Hearing Transcript

Project:	EN010148 - Tween Bridge Solar Farm
Hearing:	Issue Specific Hearing 1 (ISH1) - Part 2
Date:	15 April 2026

Plate 1: RVAA Process (TGN O2/19)

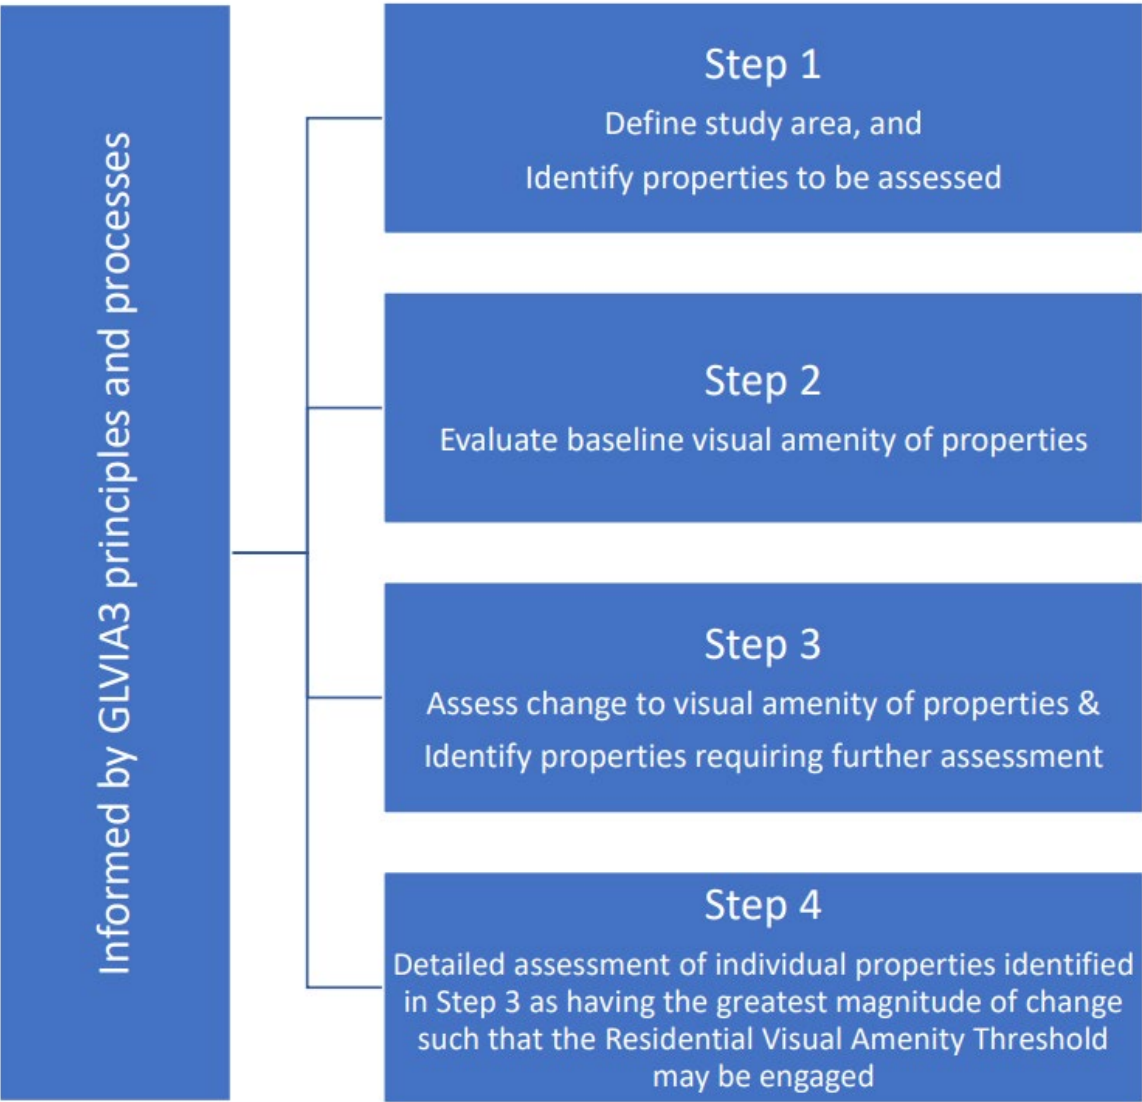
I don't think that's necessary. I think we will. If you could do so, you could either amend that table or make a submission in writing that, okay, provides me with that summary, I'd be grateful. Okay, so the next few questions relate to the applicant's residential visual amenity assessment, which is exam, Library Reference, a, PP, 062, okay, so if the applicant could display that on screen. That'd be helpful. That's a PPP 062, and paragraph one, point 2.7, of that document states that a number of properties have financial involvement with the project, and due to their understanding of the scheme, despite the proximity of the scheme to their curtilage, they have not been considered for sorry within the rva and table one one lists the involved properties, and I just wondered if the applicant could explain why these properties have not been included in the ince in the assessment. So why is the fact that they're financially involved have a bearing on whether they experience adverse effects on resident visual amenity? Why should that make a difference?

Okay? I mean, the fact that you're alleging it is fairly standard isn't really a justification. Why does the fact that they're financially involved have a bearing on whether they're included in an assessment of residential visual amenity or not.

Yes, okay, Hi, yes. Emily Jones, city of Duncan's Council and Northampton Council, we would question whether the rbaa is thorough because it does seem quite limited. It does focus on just the panels and doesn't relate to all the other infrastructure that's going in, such as the substations and the busses and, for example, the topic you've just been talking about now property labeled as 44 is completely surrounded by solar panels and without further detail in the rva. We're not sure whether that one would be a property, for example, which should have triggered the stage four. So we would like to see more detail in the RVA and be ensured that it has considered all this other infrastructure in both the rva and the LVA a the infrastructure hasn't been considered sufficiently Okay.

Curtis, on behalf of the applicant, it's it's a fairly standard practice to take out the involved properties in a residential amenity study. We have visited several of them, and we've looked at them in the context of understanding the baseline as well, and these are all set out on the accompanying figure, which is under a P, P, 149, and they're circled as as yellow on that diagram, and where We have had dialog with some of the residents directly and visited some of those properties. But it's fairly standard to take these out.

Curtis on behalf of the applicant, because they have some control over over the how the projects developed in relation to their property.

Kate Curtis, on behalf of the applicant, the purpose of the residential visual amenity study is to assess essentially, private views, not, not, not public views, which is the purpose of the environment the Ibia two fundamental differences.

Okay, can I just add to that? Because just to bring back to your point around the reference to financially involved and I think that that goes to the heart of it. The purpose of the assessment is to consider the implications on on private views when we refer to financially involved parties, those are people that have entered into an agreement with the applicant in relation to the proposed development. Proposed development, and therefore can be deemed to have accepted the principle of development on their private view by entering into an option agreement or some other form of legally binding an agreement. And it's in that context that those parties were excluded from the scope of this because, as I say, the fact that they have entered into that agreement indicates that they, whilst there might be an impact on views from their Property, they've accepted that impact.

Document Reference: 6.4.6.2

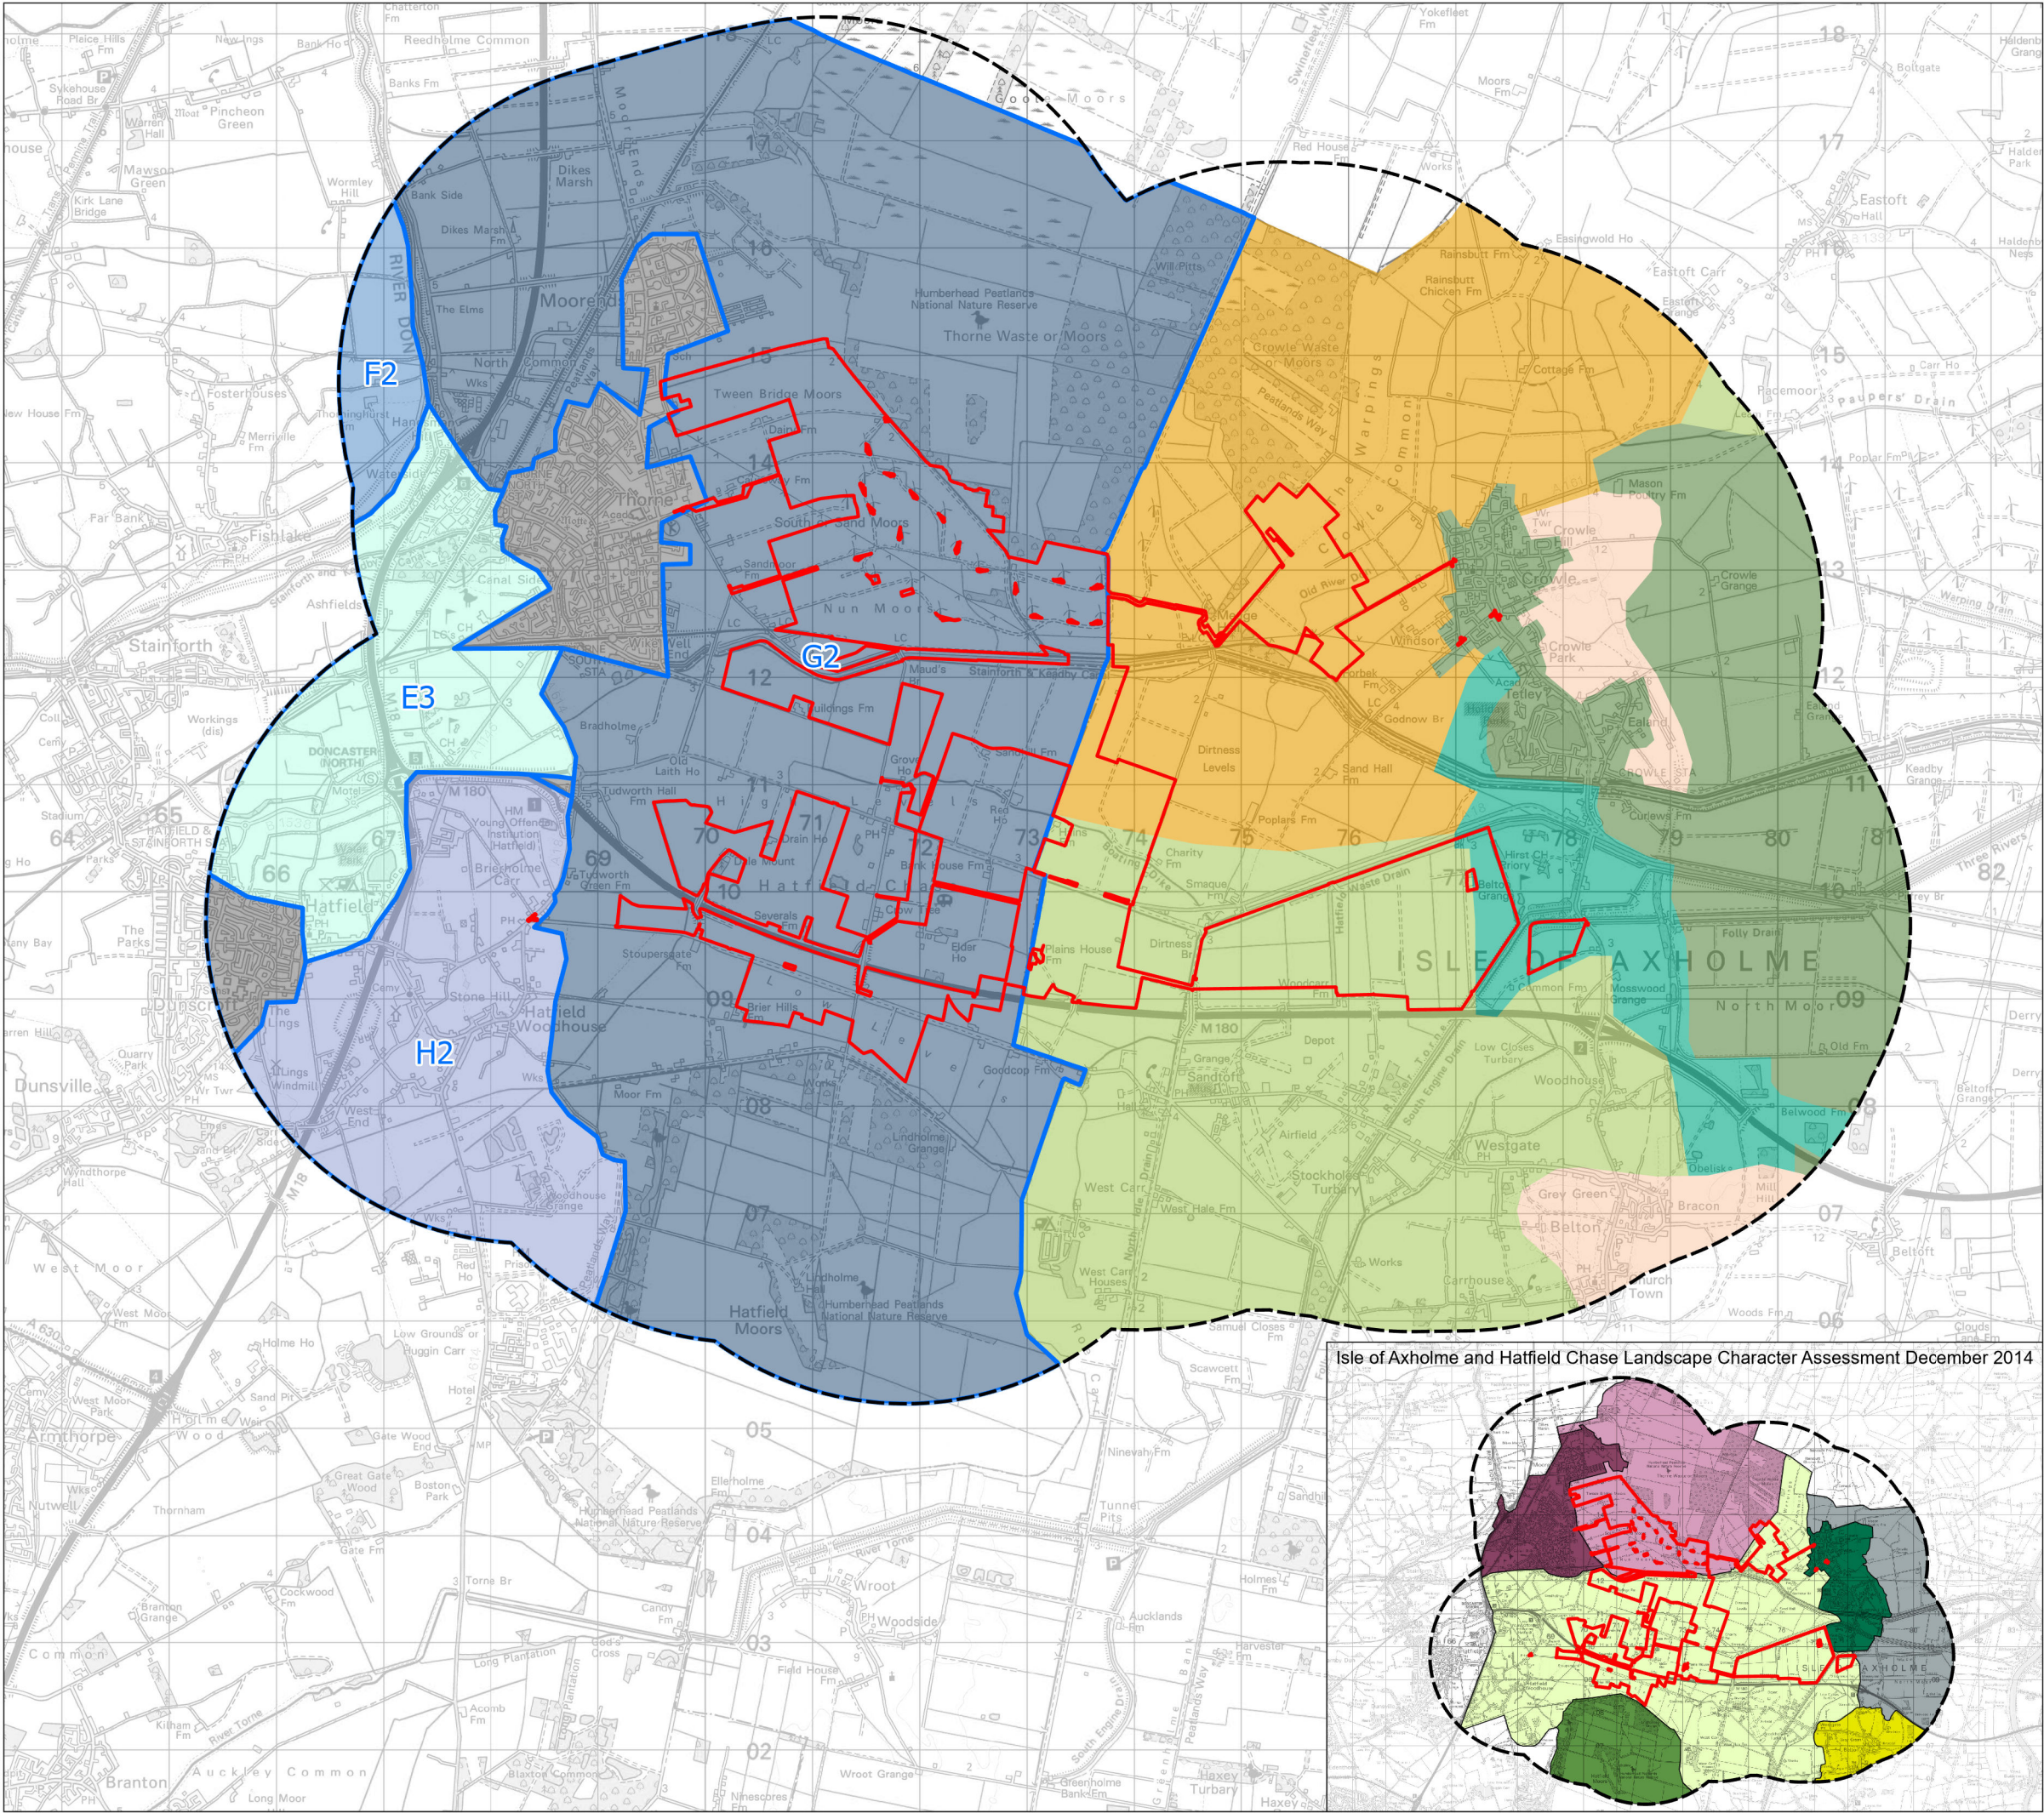
Okay, but I think my question is, why? Why does the fact that the scheme only occupies, or would only occupy, a small proportion of any respective landscape character area? Why would that be a mitigating factor?

Hello, yes, for a point. Sorry, yeah. Emily Jones from Tetra representing city of Duncan Council in North Lincolnshire. We do have some concerns regarding how the landscape character has been assessed. Within the lbia, there are other available landscape character assessment guidances documents which haven't been referenced, and we feel that perhaps the detail isn't there in the assessment. So for example, there's the Isle of axome landscape character assessment from 2014 which hasn't been referenced in the Lvia. We would have expected that to have been

okay, but on the specific point of the applicant is effectively saying, in most instances, well, the proposal only occupies a small proportion of this landscape character area, and therefore there's no significant effect on it. What is your view on that approach.

I think we feel that should be more detail in addressing that point, rather than just summarizing it as a small proportion. It may come to the same conclusion, but just a small, brief statement to say that isn't sufficient.

Kate Curtis, on behalf of the applicant. We're looking at several landscape character areas here in the Doncaster authority area, we're looking at g2 Thorn and Hatfield peat moorlands in the north Lincolnshire area. We're looking at flat, open, remote farmland, flat wooded farmland and flat drained treed farmland, for example, at paragraph six, point 5.0 we do acknowledge that there would be significant effects within those landscape character areas over the area that the the the application covers, but We do note, because they are larger spatial areas that the significant. The effects are not significant over the over the wider character areas. And the character areas are displayed on a plan at figure.

It's figure 6.2 landscape character areas, which does give you the spatial area of those landscape character areas and gives you an indication of the proportion which the application sits within.

Because you're considering the effects on the whole of that character area, and if it's a small proportion of it, then it's only affecting a small proportion of the character area. Okay, it's a fairly standard approach that.

Kate Curtis, on behalf of the applicant, I think we stand by the fact that we identify that it's a small proportion of a wider character area and but we do acknowledge that there are significant, significant effects on those parts of those character areas that are affected by the proposed development. But when you look wider and spatially across the whole of the character area, we don't believe those to be significant.
